Application: DC/23/02326
Location: Land East Of Pettaugh Lane Gosbeck Ipswich Suffolk IP6 9SE
Proposal: Planning application - Change of use of agricultural land to equestrian use, including erection of associated stable block and construction of manège

Holding objection due to insufficient ecological information on European Protected Species (Great Crested Newt) and protected and Priority species and habitats

Figure 2.1.2 Site Location Plan

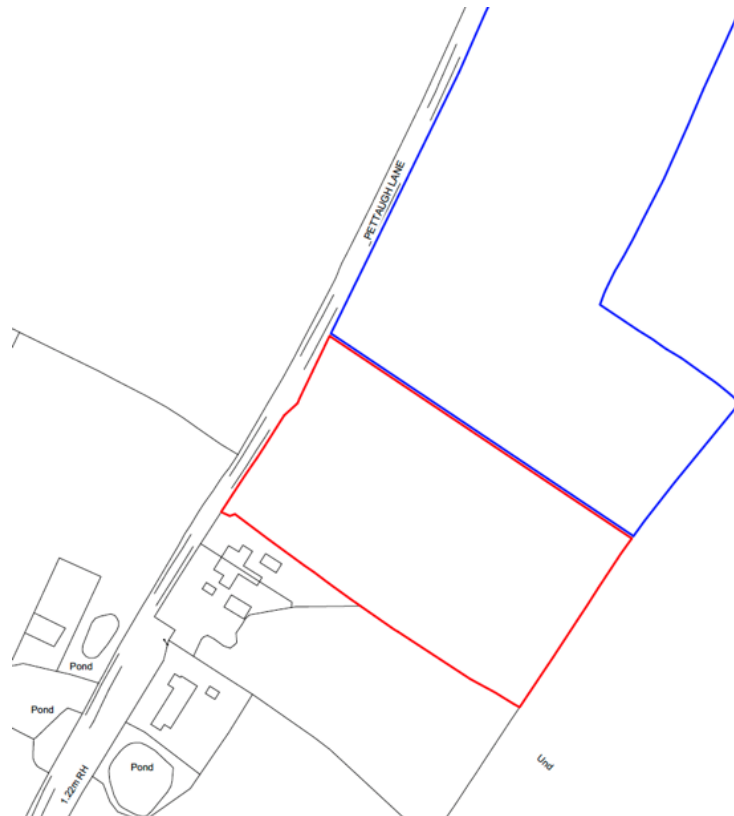
As the site lies within an Amber Risk Zone Area for [Natural England's Great Crested Newt District Level Licensing for Norfolk and Suffolk](#), there are three ponds immediately to the south of the site and a further pond immediately north of the blue line boundary (Site Location Plan Drawing Number 01 P3 (May 2023)), there may be Great Crested Newt in the area. Since construction could impact any individuals entering the site, we recommend that the ecologist assesses the site to avoid impacts on this European Protected Species. The strategic [Norfolk and Suffolk District Level Licensing scheme \(DLL\)](#) is also available in Suffolk.
